**MAJOR PROJECT ASSESSMENT:
CONSTRUCTION OF A SENIORS HOUSING
DEVELOPMENT AT 216-222 MAIN ROAD
AND 21 ROWLAND TERRACE, TOUKLEY**

Proposed by RUSTRUM PTY LTD

Director-General's
Environmental Assessment Report
Section 75I of the
Environmental Planning and Assessment Act 1979

Plan of: SEPP SL
HEIGHT NON-COMPLIANCES

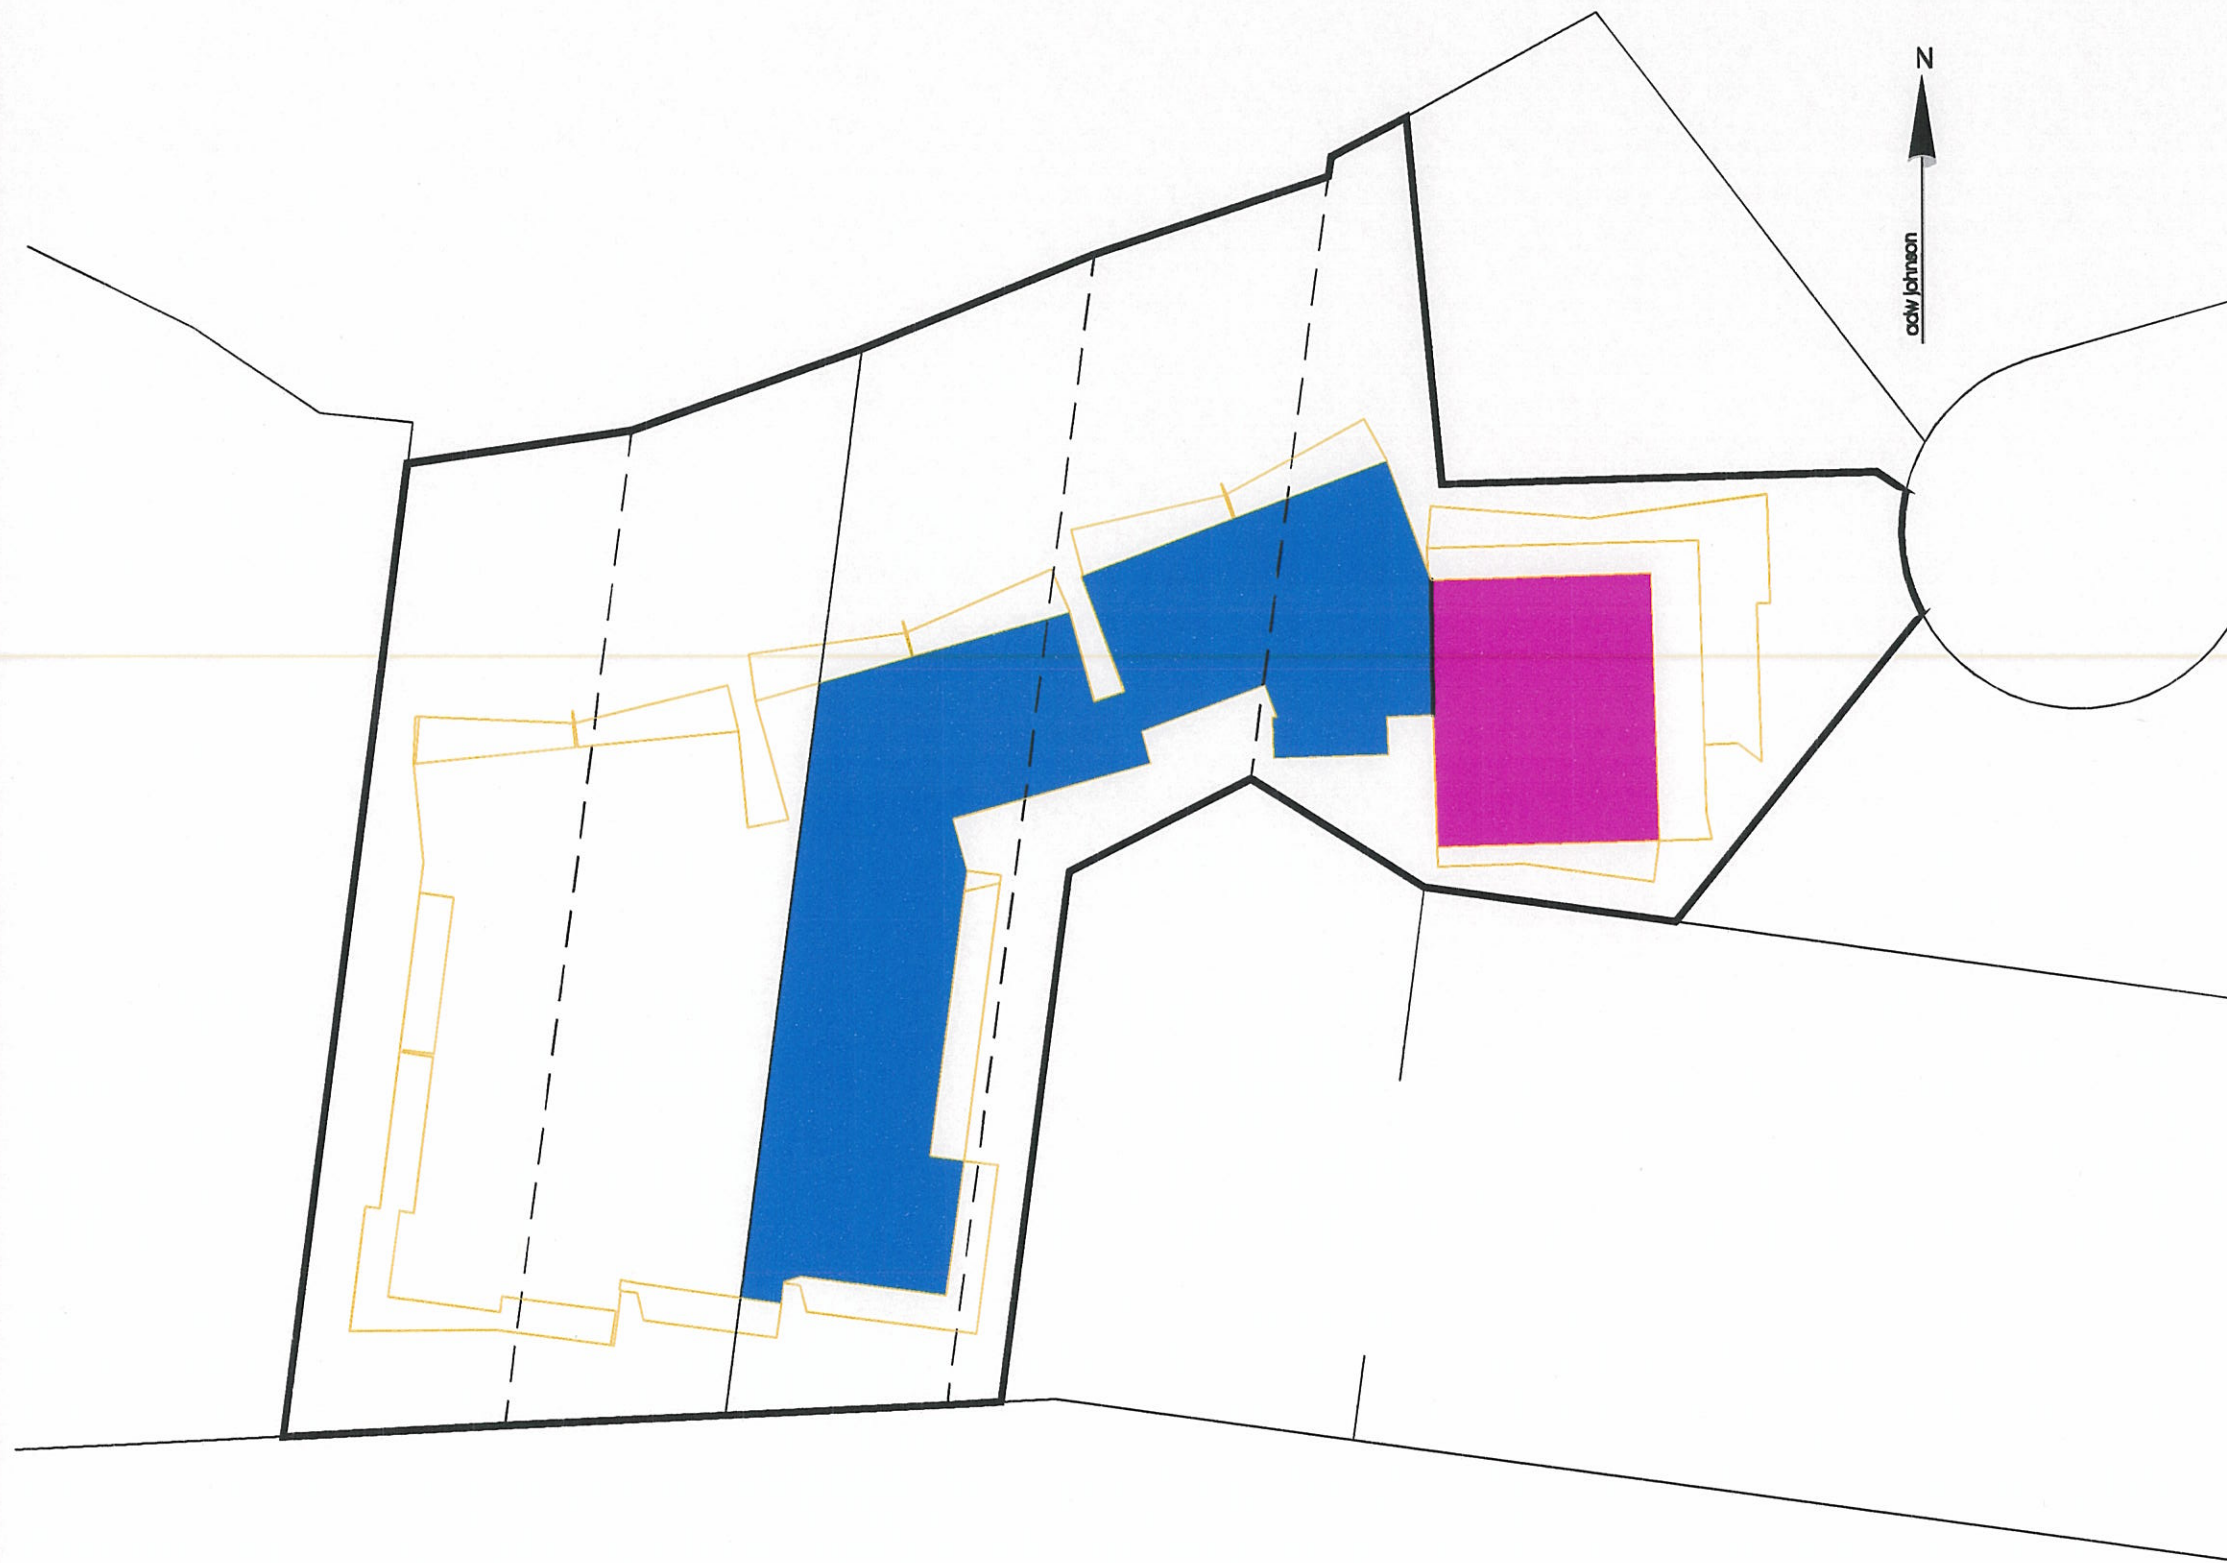
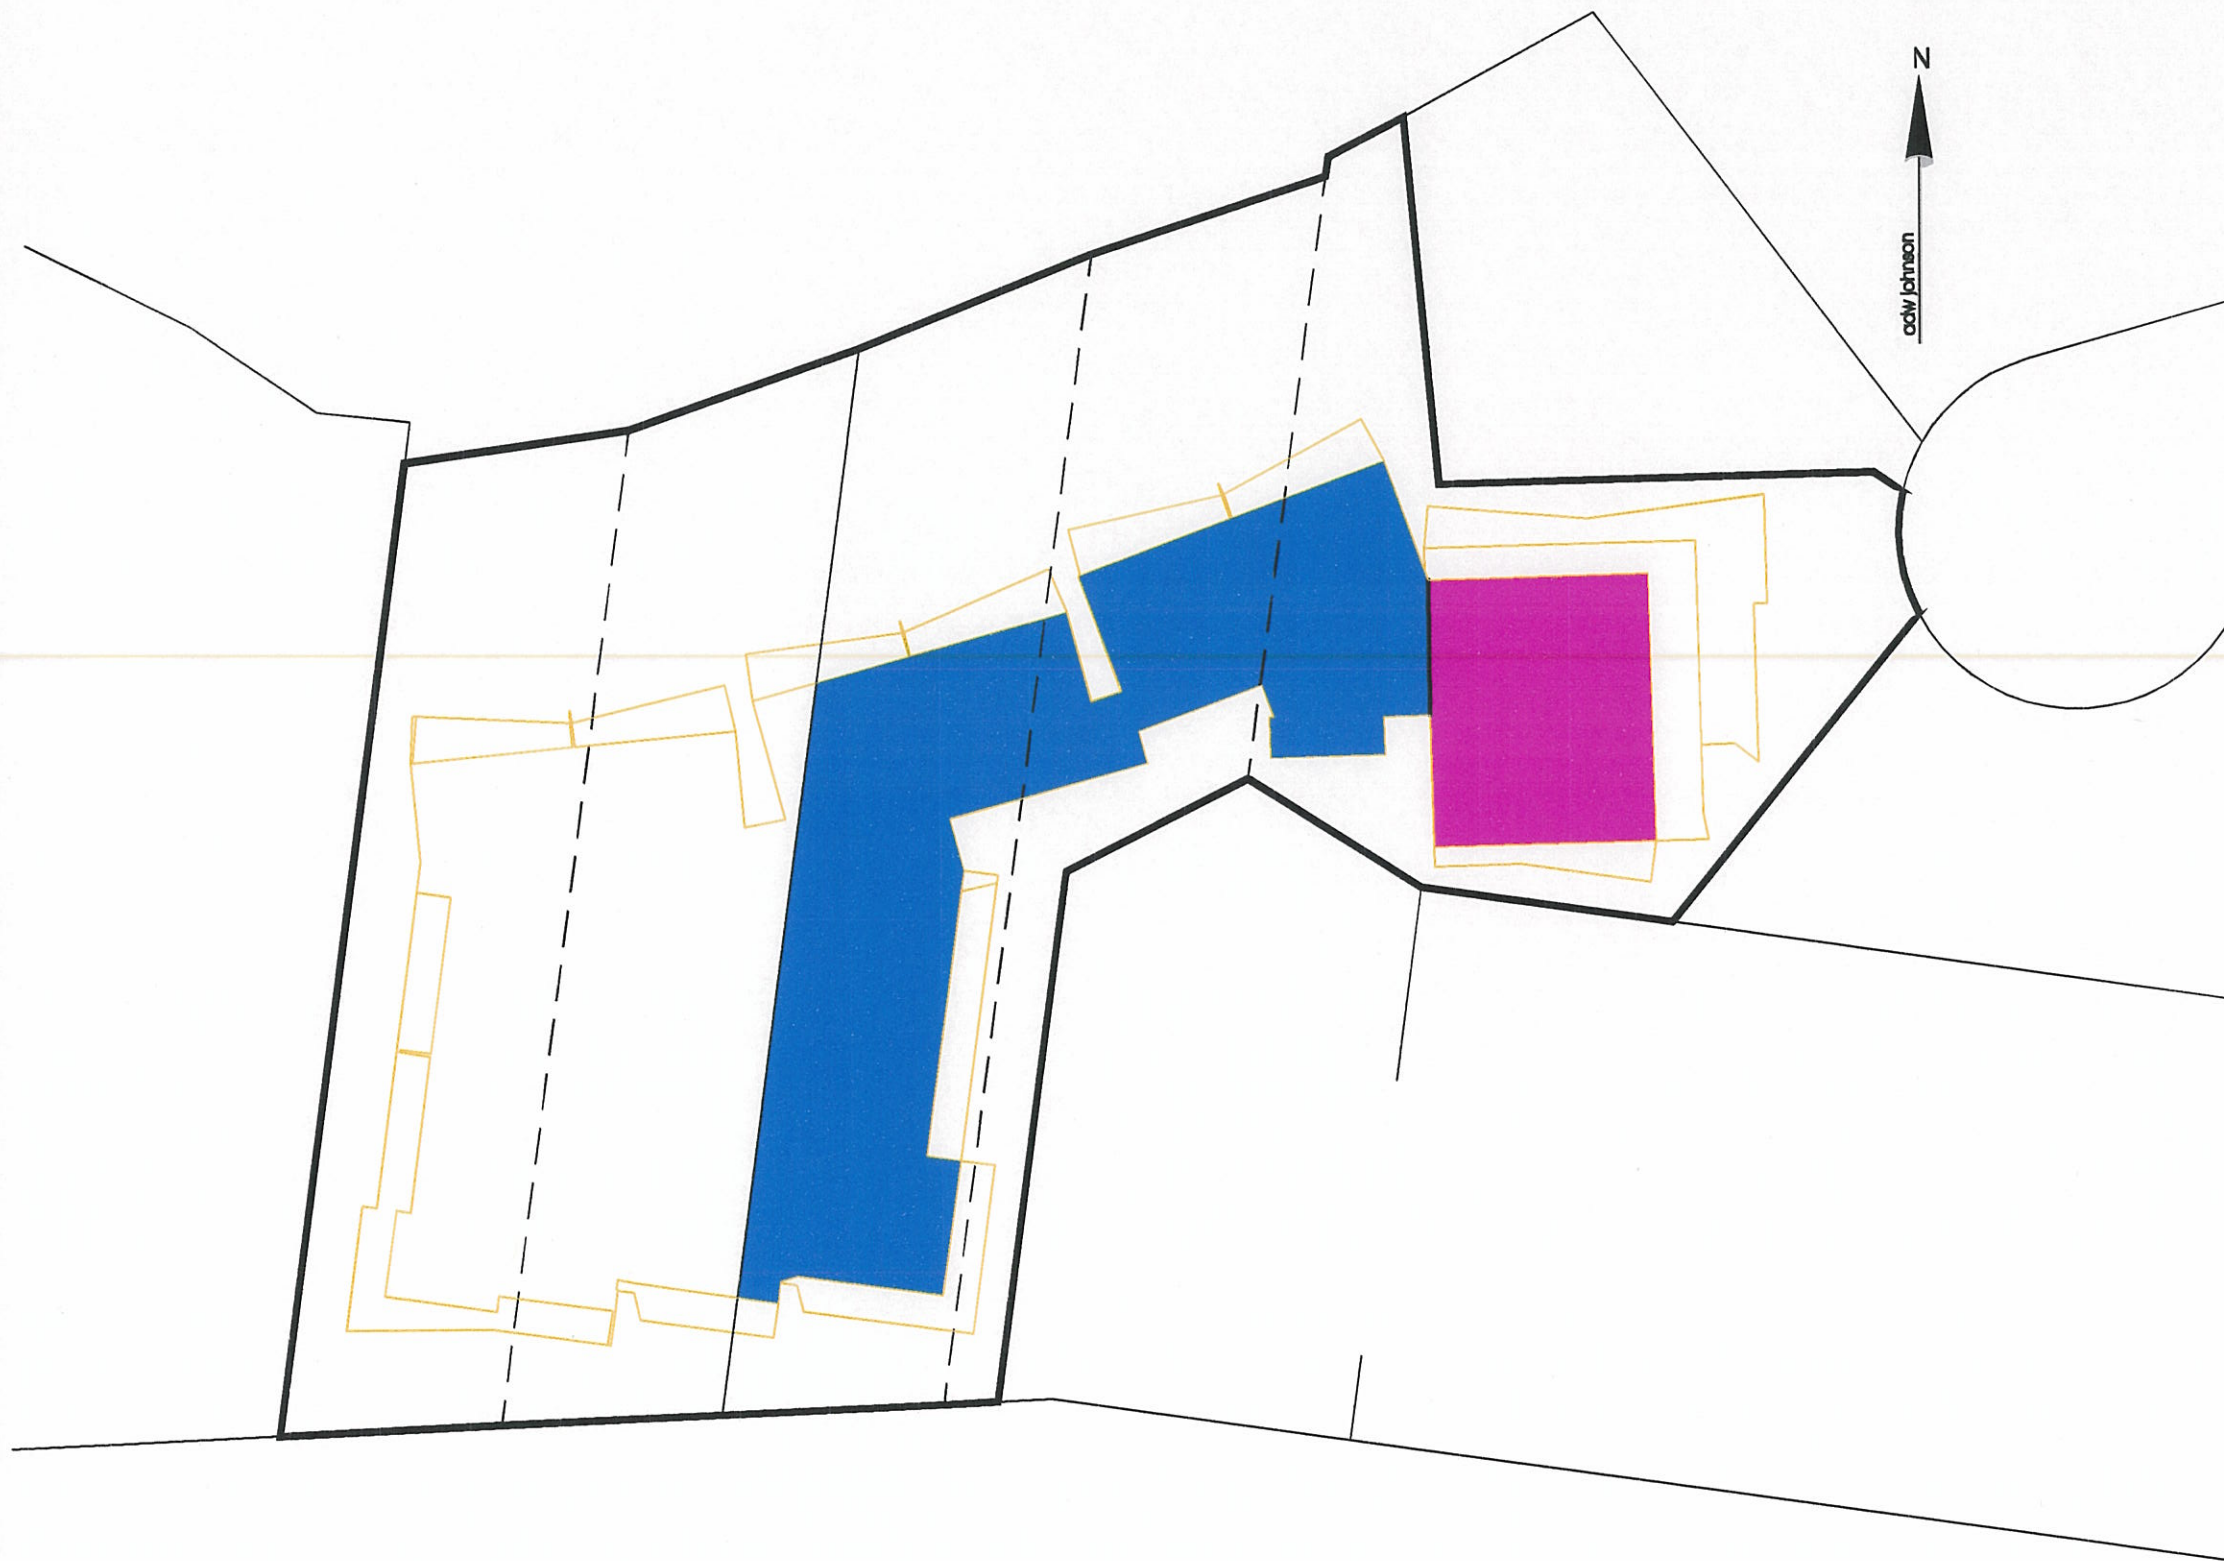
The non-compliant part of the building in the 2(a) zone adjoins a single storey dwelling house at No. 19 Rowland Terrace and Toukley Gardens Park. No. 19 is sited closer to the lake than the proposed development. The proposed building will be up to 11m above existing ground level and 3m from the common boundary with No. 19. The ridge of No. 19 is RL 6.4m and the roof of the proposal is RL 16.6 which represents a height difference of 10m. There will be no adverse impact in terms of overshadowing, overlooking or loss of views upon No. 19 due to its siting and orientation to the lake. The development would however create an abrupt change in building scale and visually overwhelm this dwelling.

In that regard it is recommended that unit 13 at level 3 be deleted. Part of the building will still not comply with the 8m height control but the change will result in a better transition to the lower scale development in Rowland Terrace. Subject to this change the Department supports the non-compliance for the following reasons:
